DOC19/919737

23 October 2019

**Stadium Australia Redevelopment (SSD 10342)
Advice on the Environmental Impact Statement**

Figure 4: Inbound construction vehicle routes

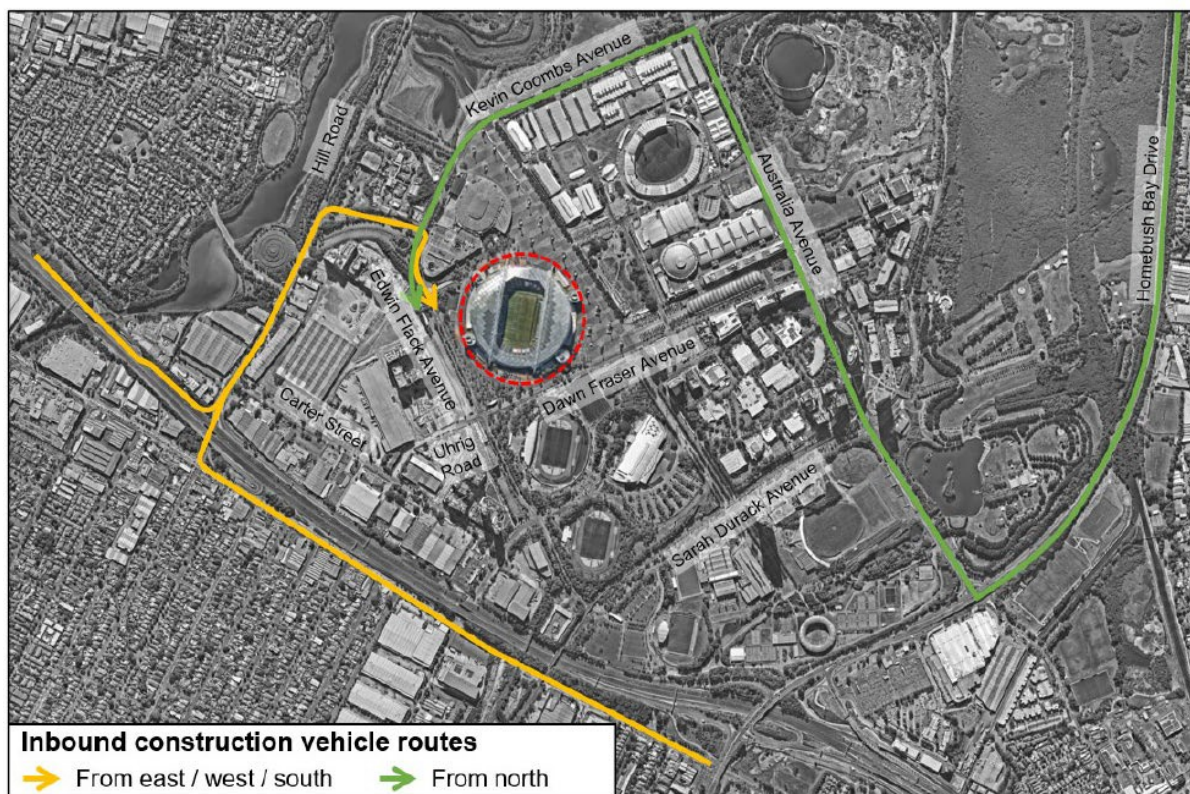
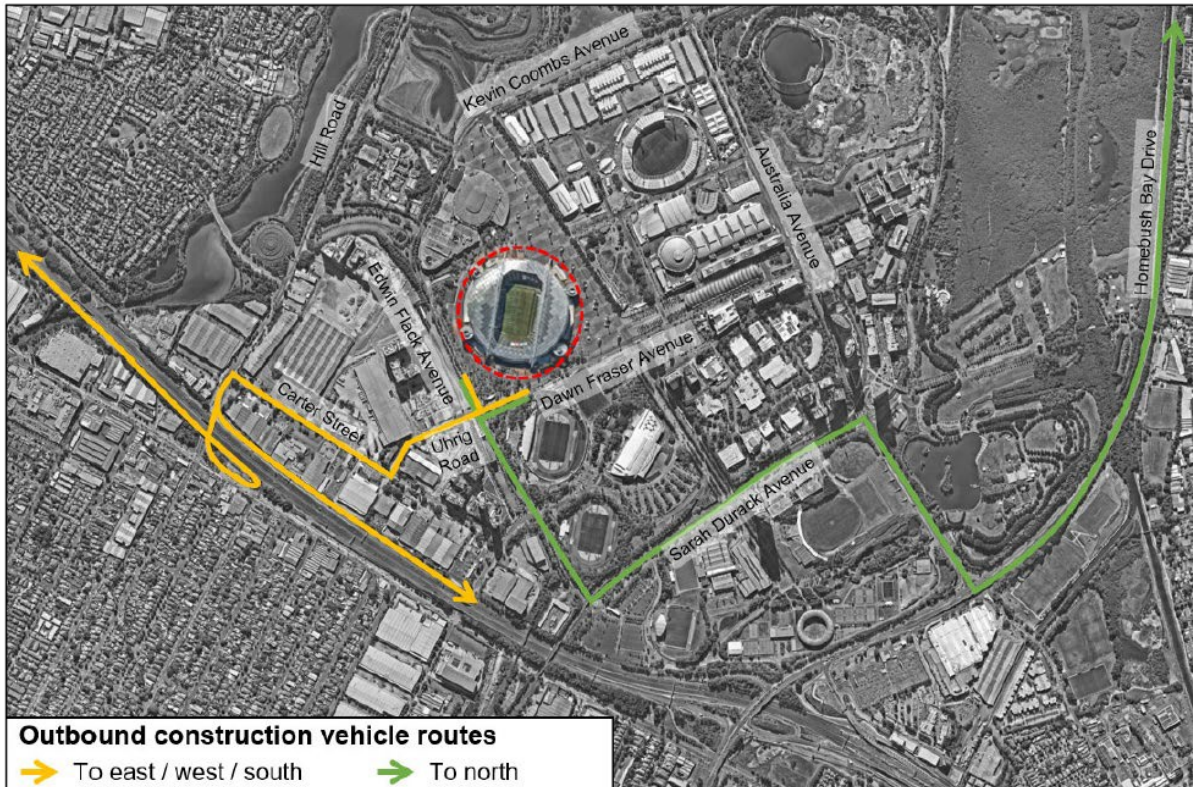
- b) The Noise Report has not considered all of the construction traffic routes that are included in the Transport Impact Assessment and therefore it is not clear if all potentially affected sensitive receivers have been assessed. The Noise Report must include an assessment of all of the proposed construction traffic routes.
- c) The construction traffic noise assessment has only considered noise levels during daytime. However, construction is proposed to start at 7am, therefore construction related vehicles may be travelling to the site prior to 7am, during the night period. The applicant must confirm the times when workers will be travelling to the site and amend the assessment accordingly.
